JOURNAL
CENTER
CORPORATION

RE: 7801 Tiburon Street NE, Albuquerque, NM 87109
Legal Description: TR 5C-1B-1 PLAT OF TRACTS 5-B-1-A-1-A-1, 5-B-1-B-1-A, 5C-1A-1, 5C-1A-2,
AND 5C-1B-1 JOURNAL CENTER (A REPLAT OF TRACTS 5-B-1-A-1-A, 5-B-1-B-1, 5C-1A AND 5C-1B
JOURNAL CENTER)

The Journal Center Architectural Review Committee (JCARC) has reviewed the proposed amendment to the current Site Development Plan package submitted by Jorge Gonzales, Architect and Jimmy Hendrix, Set Designer with NTM, LLC Loud House TV Series on behalf of Journal Publishing Company, owner of the referenced property. The JCARC approves the proposed amendment, which will allow use of a portion of the site as an outdoor filming area, with the following conditions:

EXISTING SITE PLAN

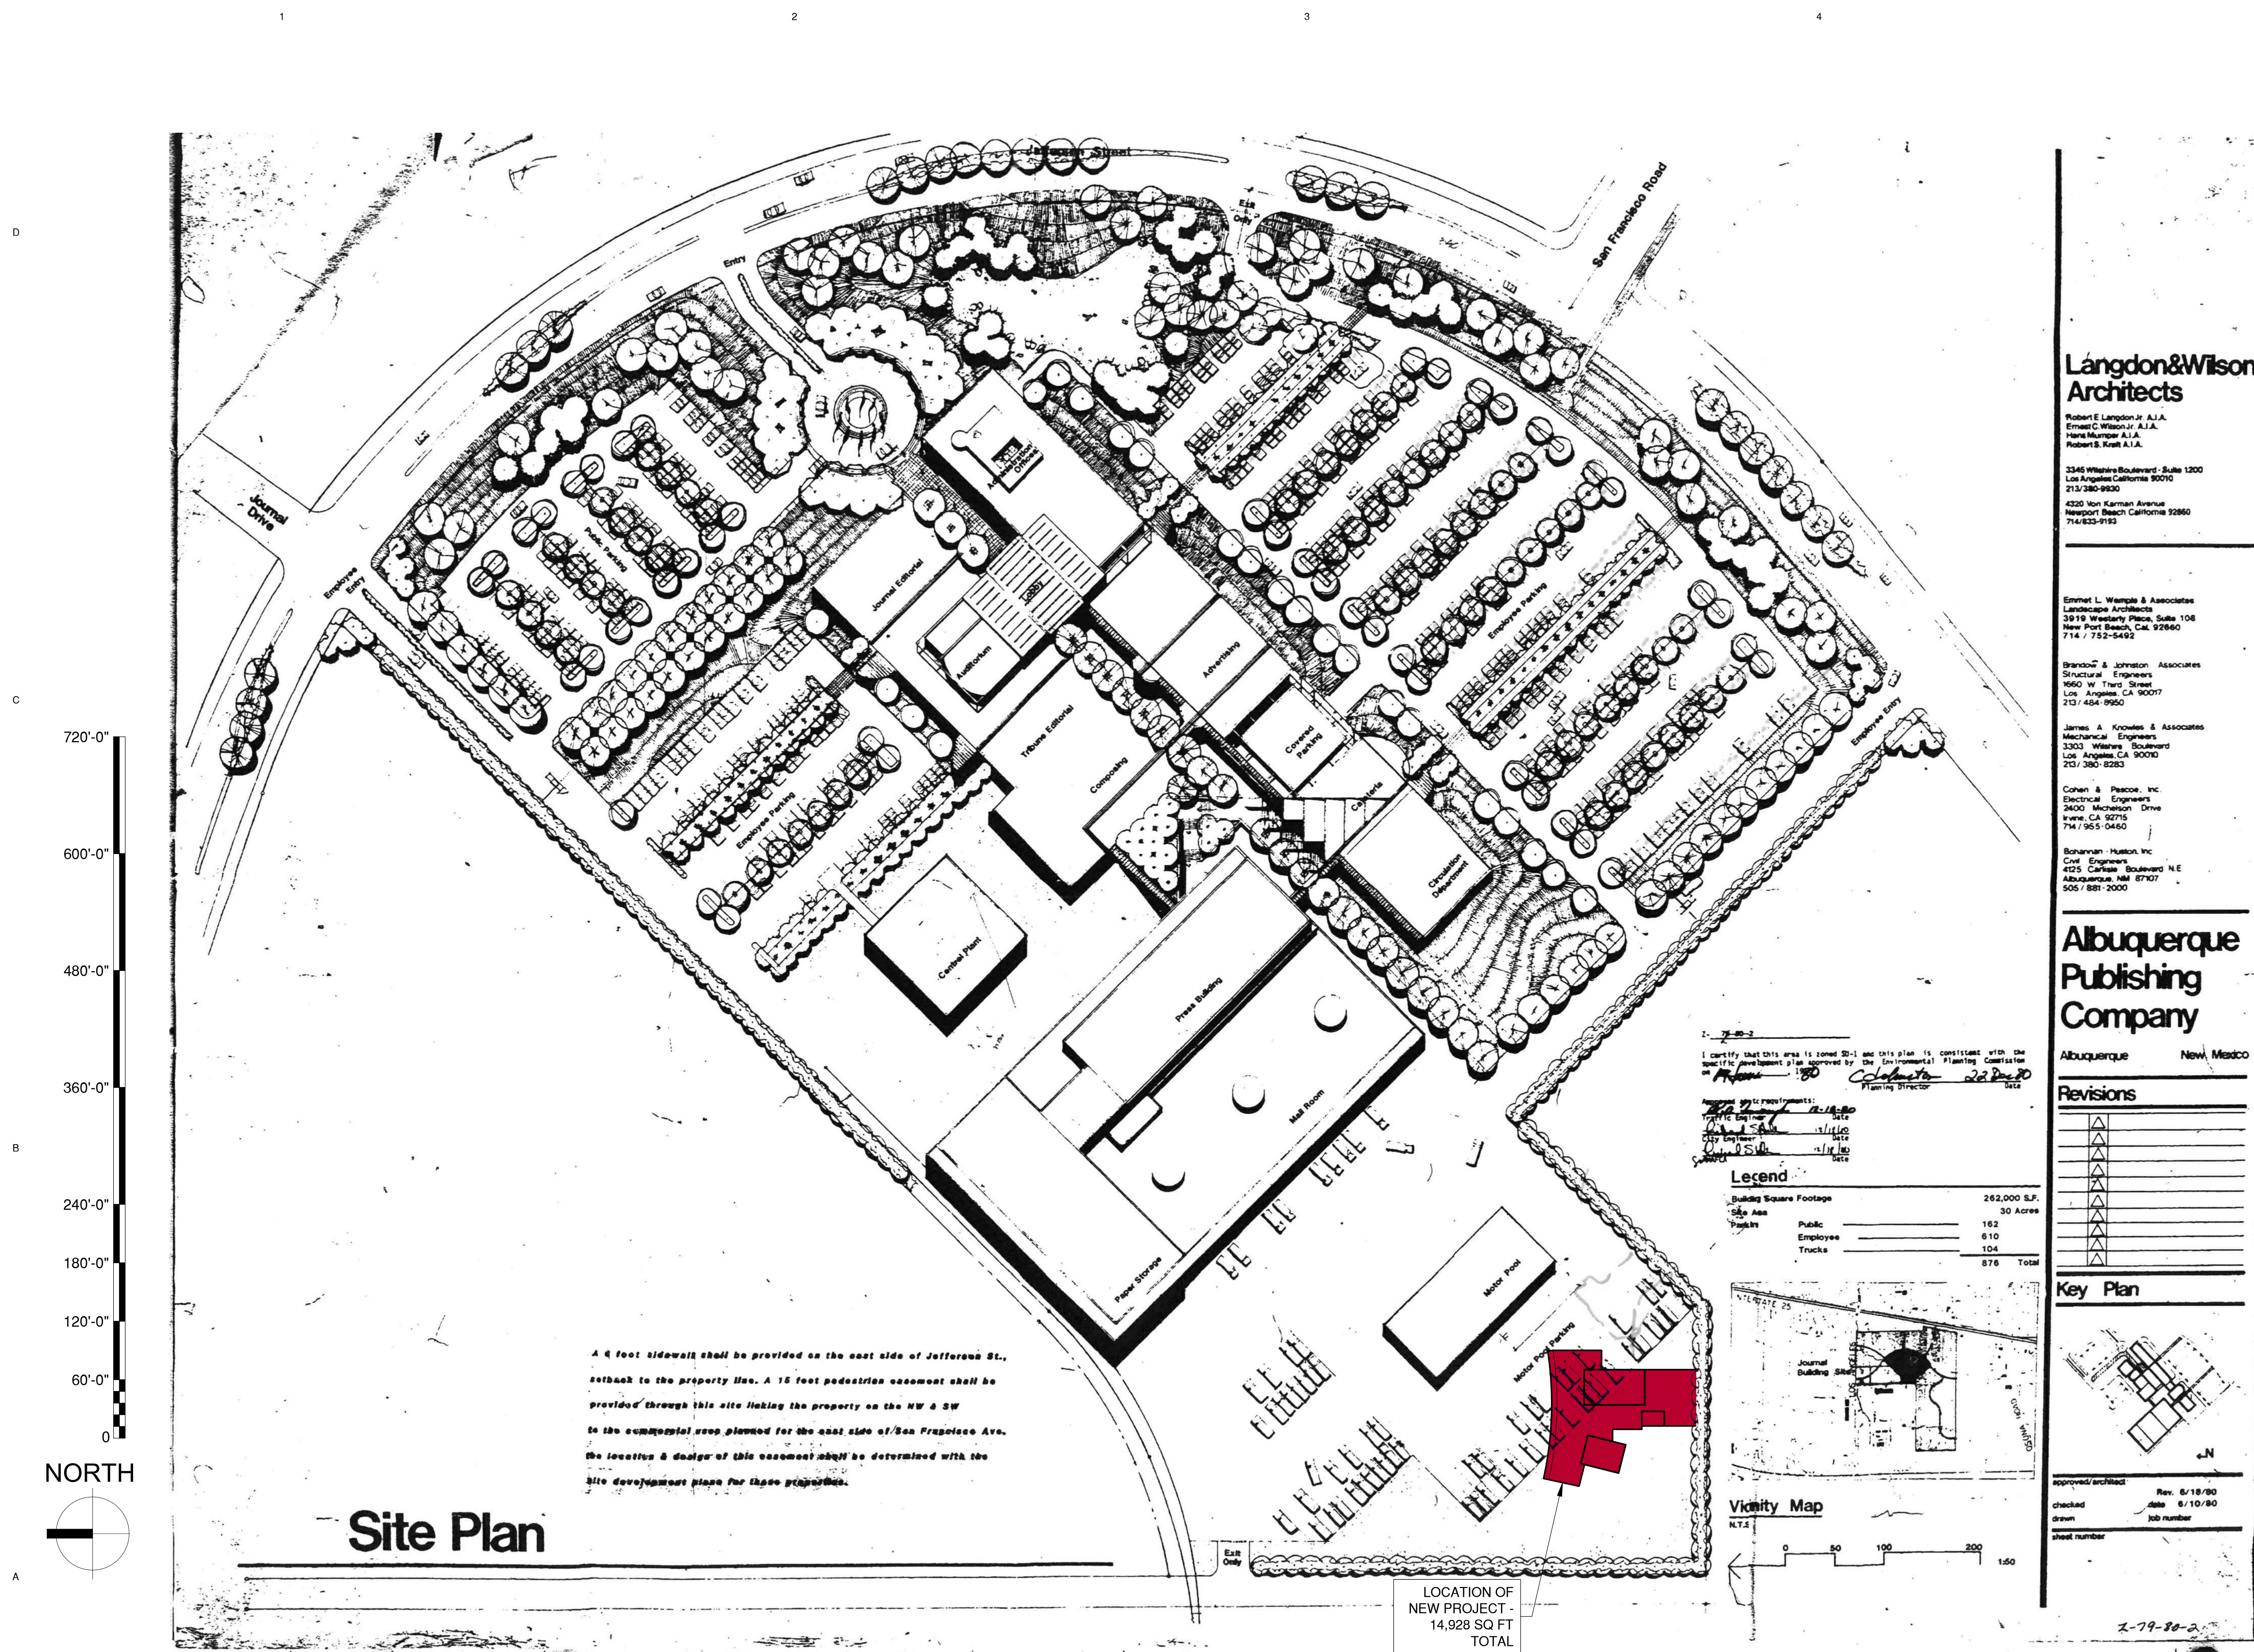
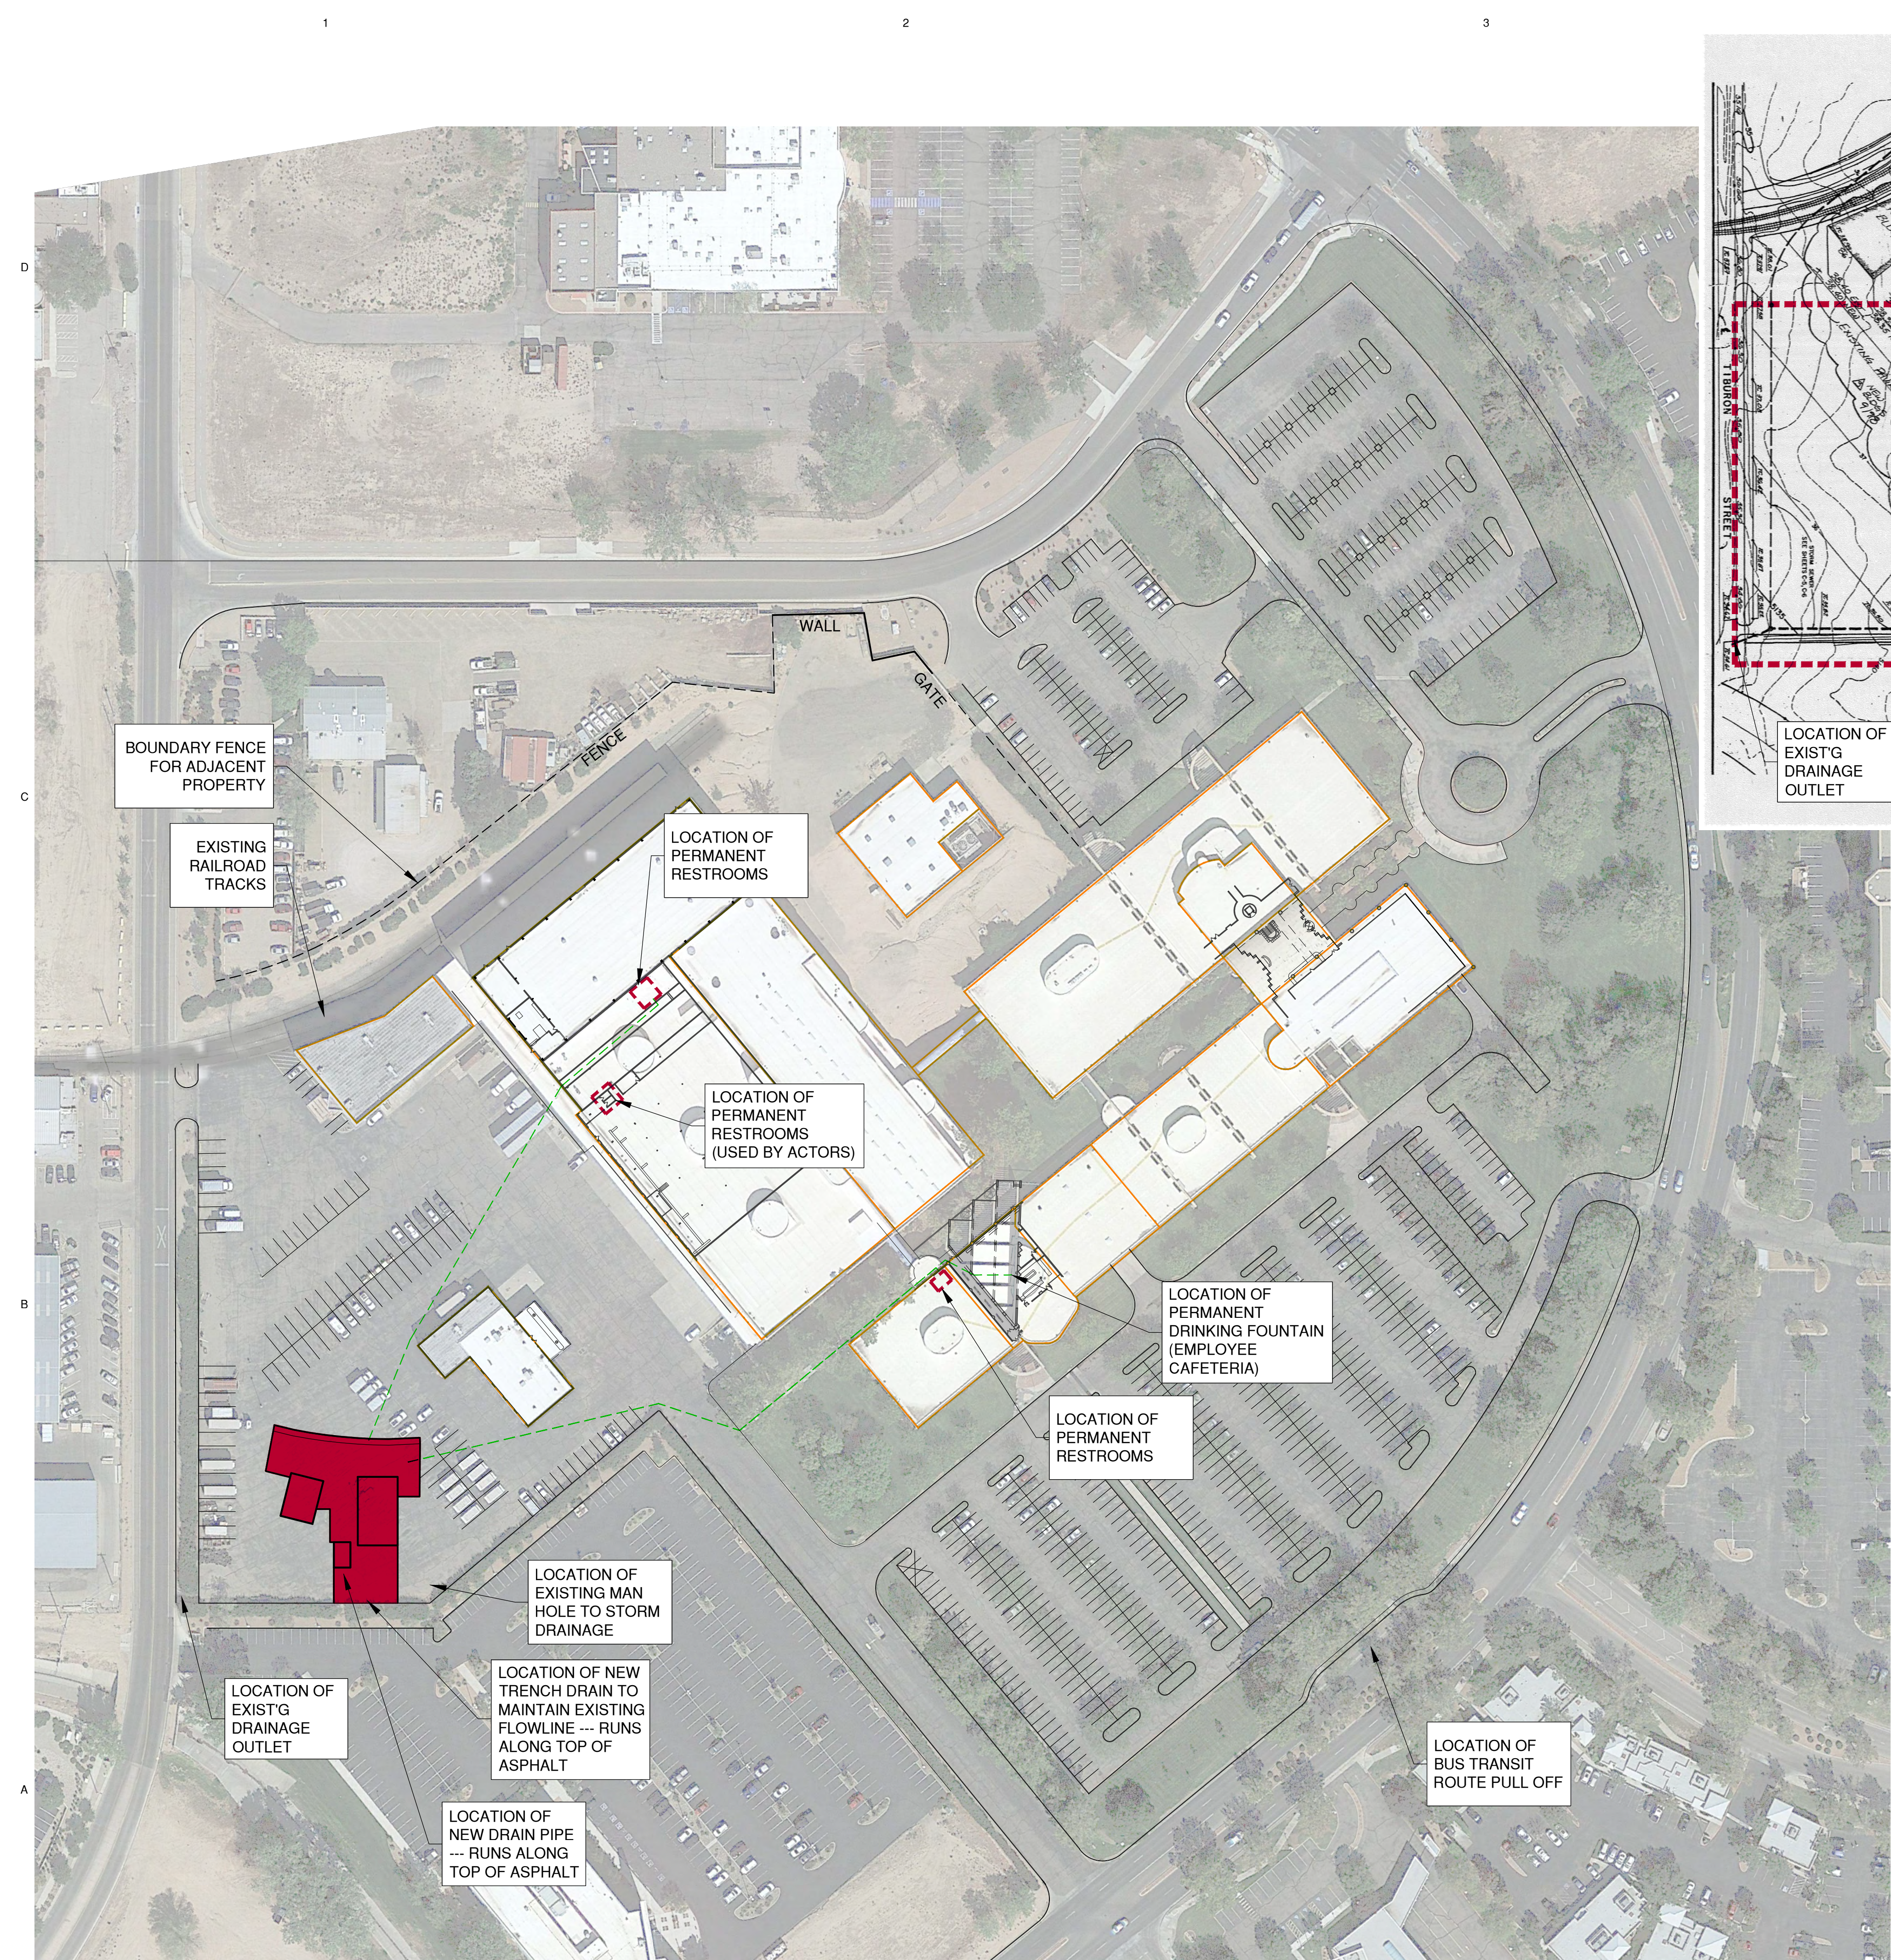
1. Any unfinished portions of the exterior of the existing "house" structures shall be completed so they appear to be finished buildings.
2. The existing pyracantha hedges along the property lines shall remain and be maintained as a visual screen for adjacent properties and the public roadways.
3. This approval of the use of the "house" structures is temporary and shall expire eighteen months from the date of this letter unless an extension is requested of and approved by the JCARC.
4. Construction of any future outdoor film set structures shall require the advance review and approval by the ARC.
